From: Farhad Khatibi
Sent: 29 May 2024 12:01
To: Planning ContactCentre
Subject: RE: Attached letter from Kirklees Council regarding application number 2024/91430 at location 161-165, Lane Top, Royd House Lane, Linthwaite, Huddersfield, HD7 5SG

Bridges & Structures Manager
Structures Section
Highways and Streetscene
Kirklees Council

Drawing Title  
Planning Drawing - As Proposed

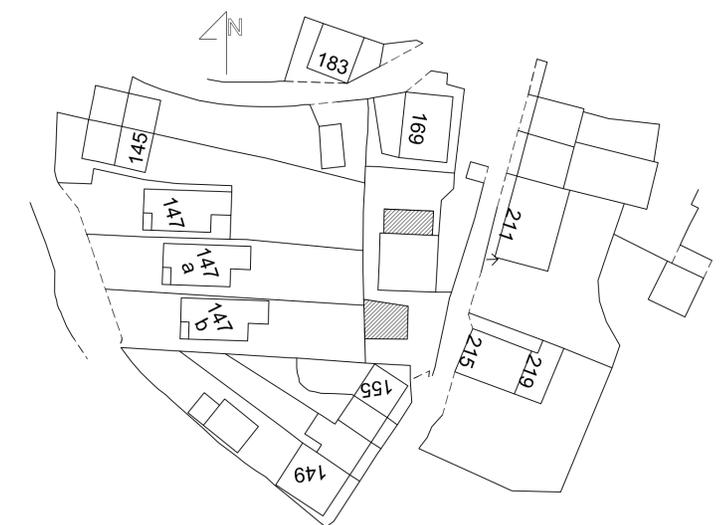
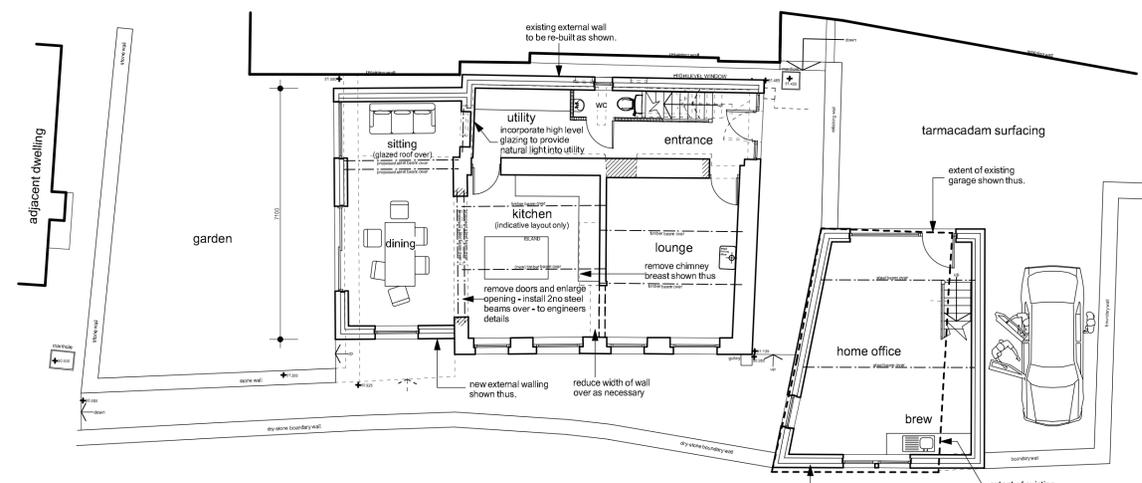
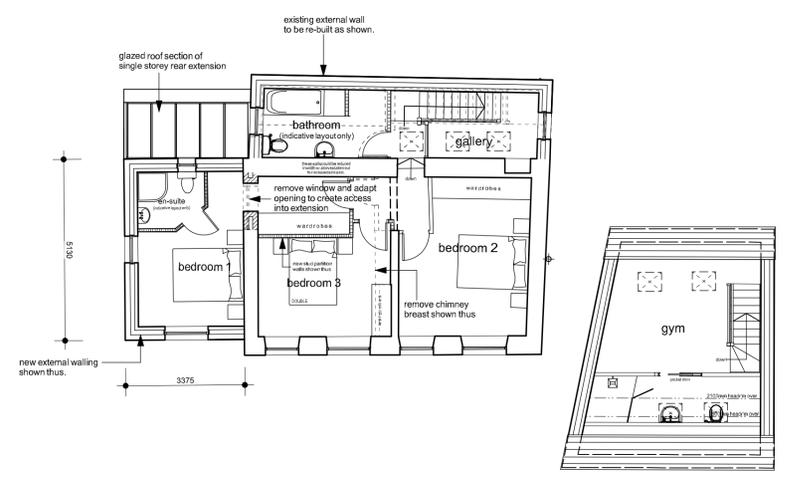
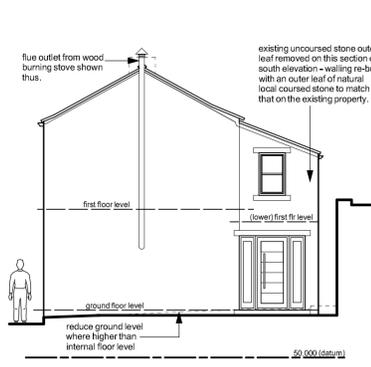
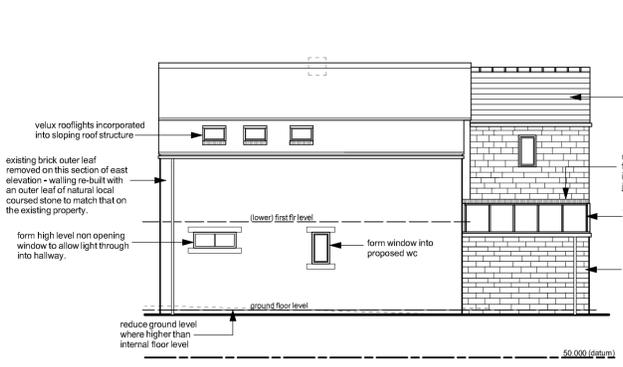
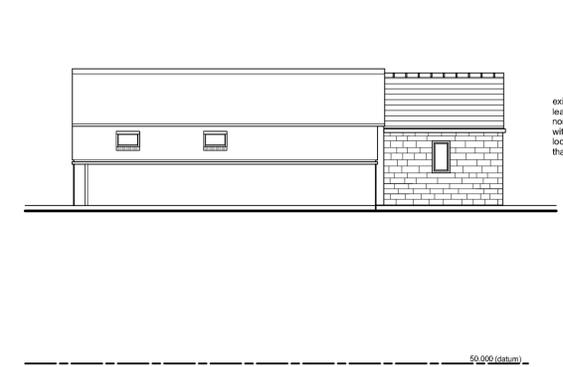
Please advise the applicant or his/her agent to submit a fully detailed and dimensioned X-sectional drawings perpendicular to Royd House Lane to assess the impact of their proposals on the adjoining highway and determine whether a formal technical approval (via submission of an AIP) will be necessary.
